Application: AL/94/14/L
Alterations and Single Storey Rear Extensions to;
The Manor House at Aldingbourne, A Grade II listed building

I am pleased to submit our revised application and proposal drawing A1Q9685-3(p) and I appreciate your help and willingness to work with us on this project. We are mindful of the time that has now passed however and trust that you can work with us to ensure the swift processing of the application and speed things along to help minimise the delay and added cost to our client.

Drawing No.  
A1Q 9685-3(P)

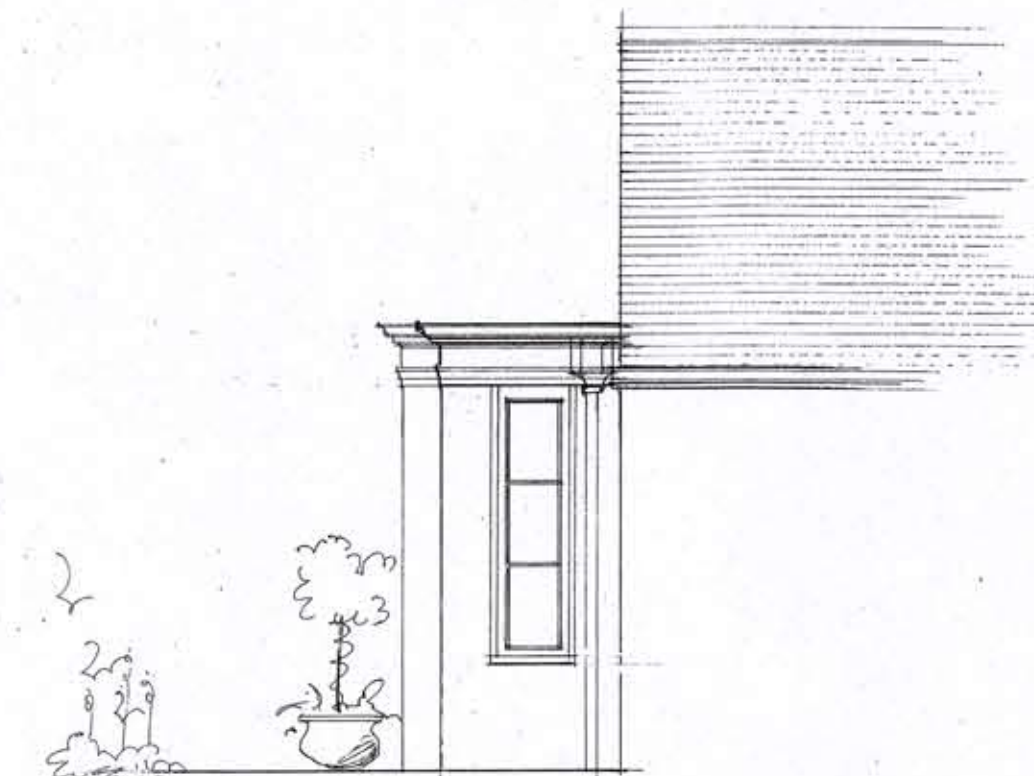
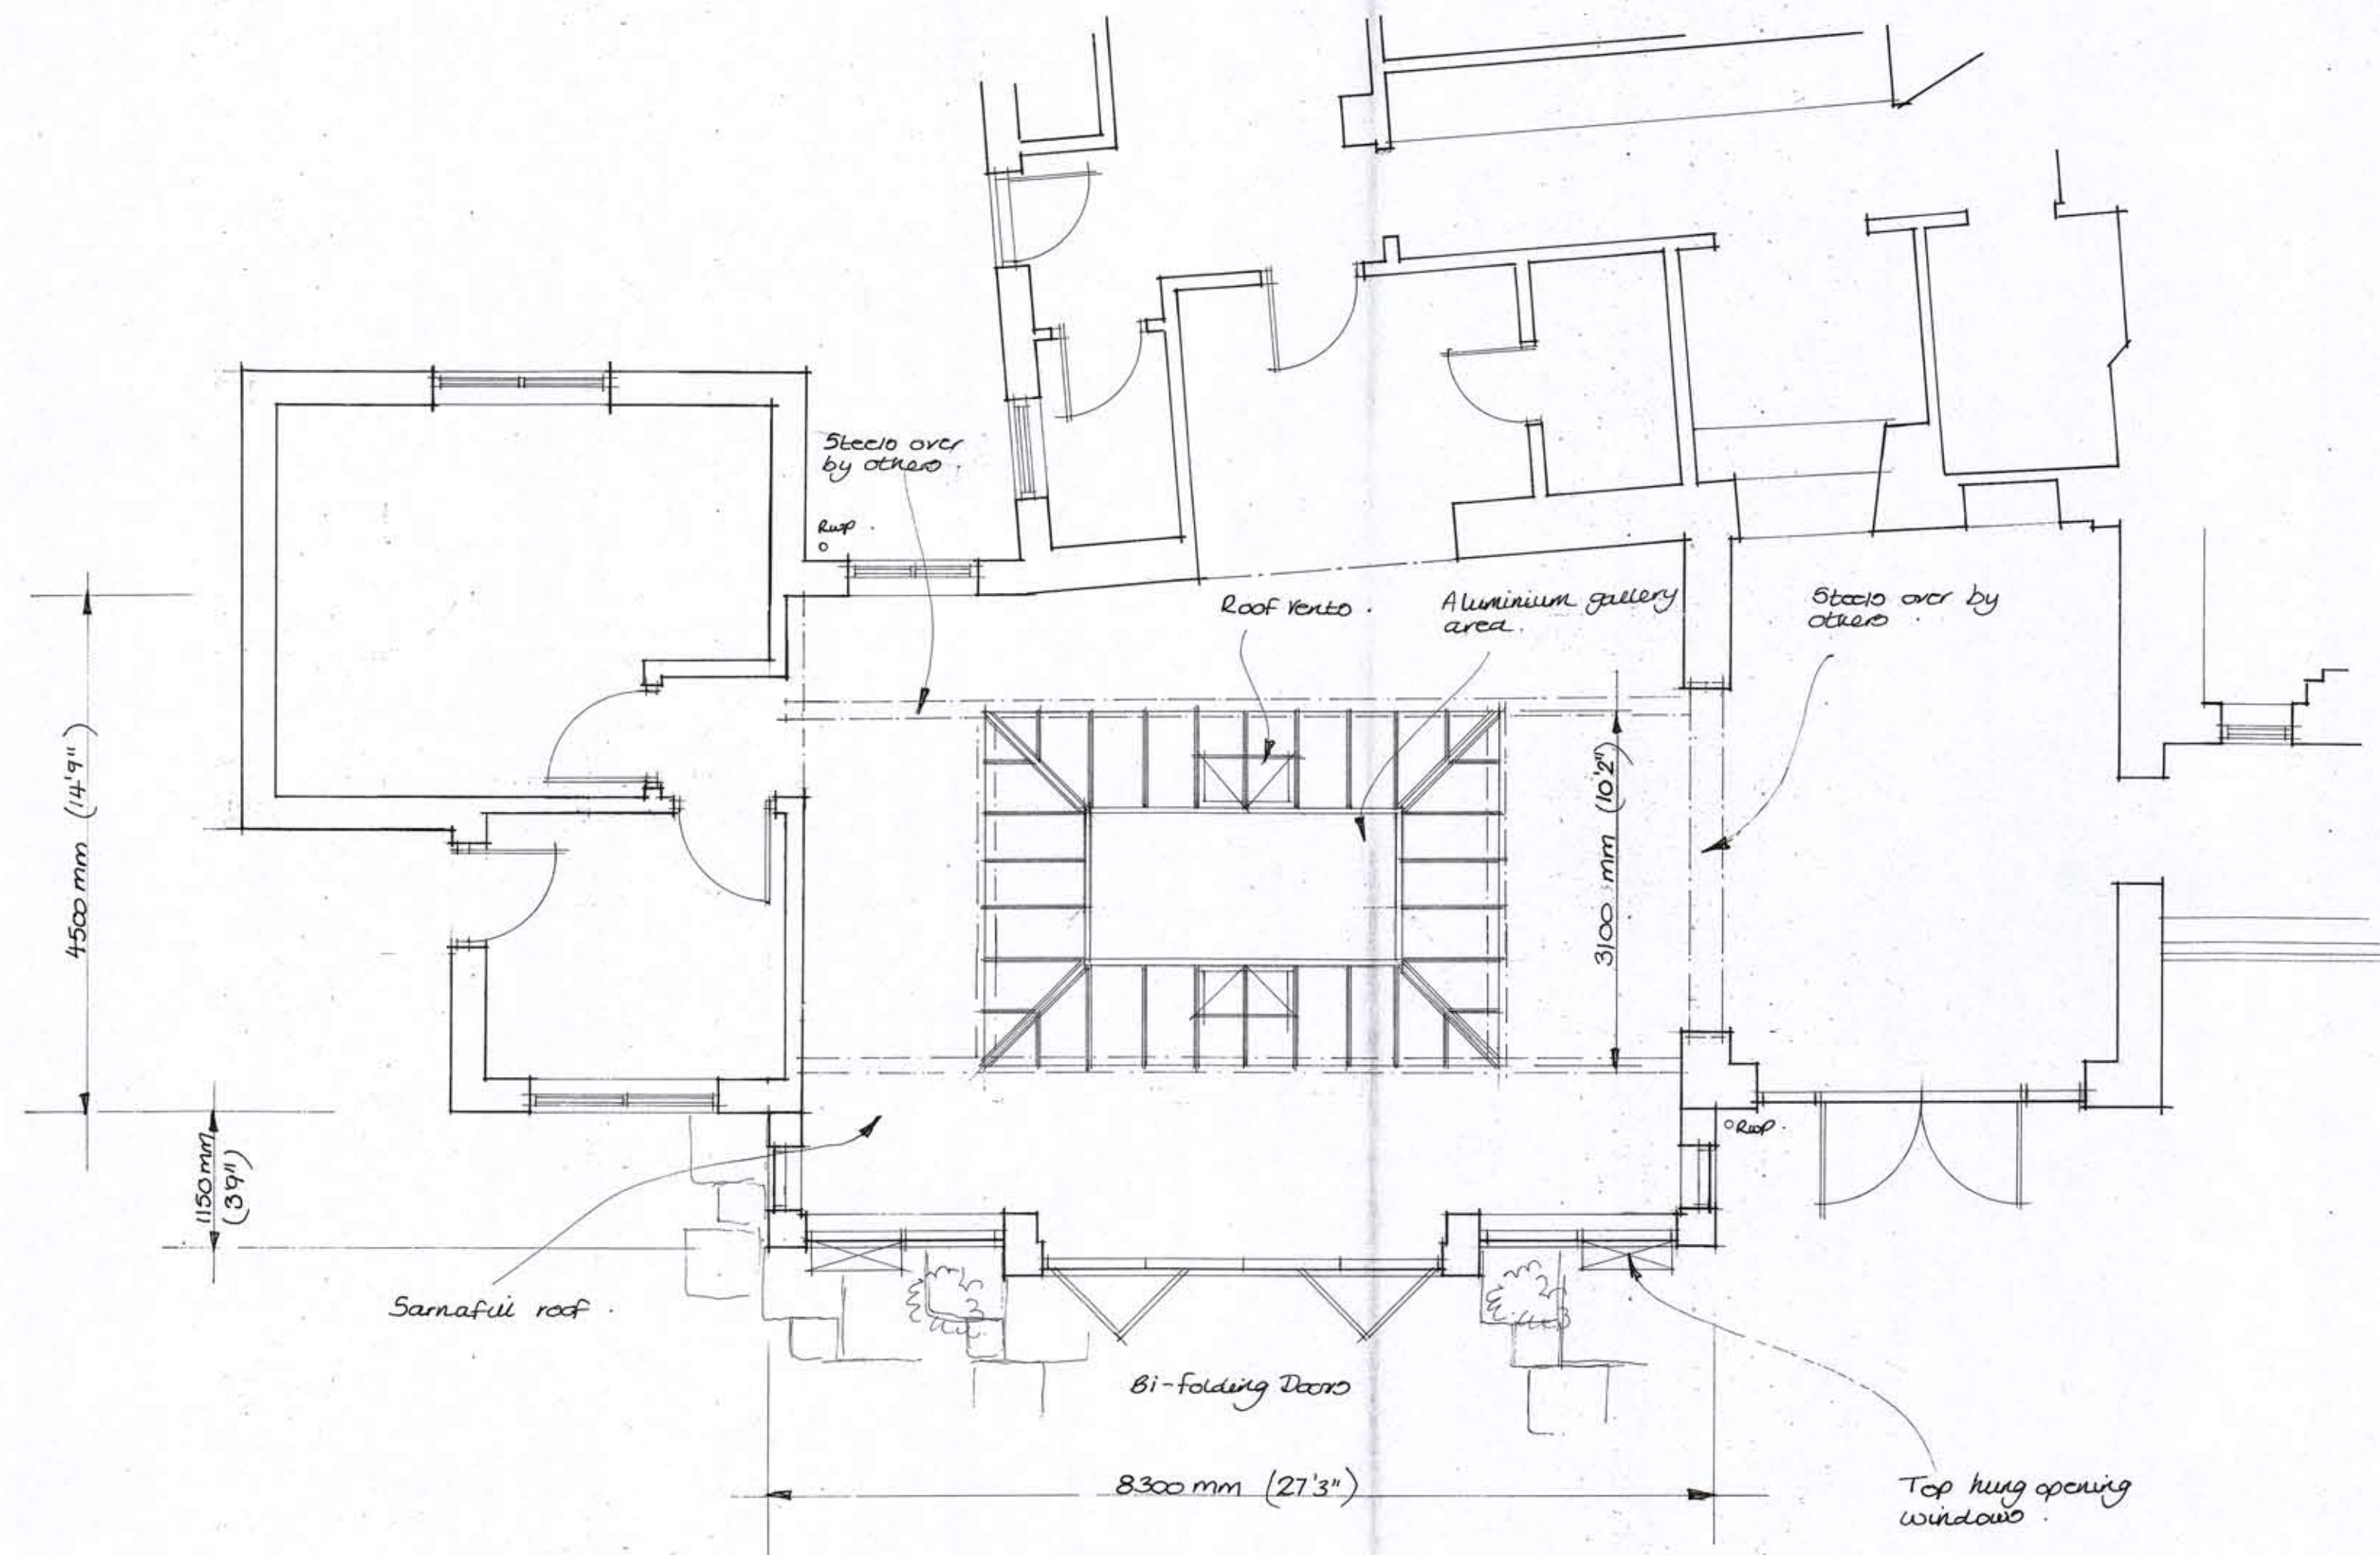
1. The apparent scale of the orangery will be reduced in a North/South direction to protrude less Southward and also in an East/West direction by reducing the frontage width.
2. The roof lantern will be reduced in width, depth, height and the top will not exceed the glazing of the first floor dressing room window.
3. The parapet of the orangery is a straight forward butt joint with an existing wall face at its eastern end and a replica on its western end. Large scale drawings will be provided with the substitute proposals.
4. To make the proposed orangery look more sympathetic and less imposing, the full and half height pilasters are removed and replaced with gauged brickwork piers. This change reduces formality and is an understated solution but retains the openness and light weight touch of the orangery approach the Mr Wightman supported.
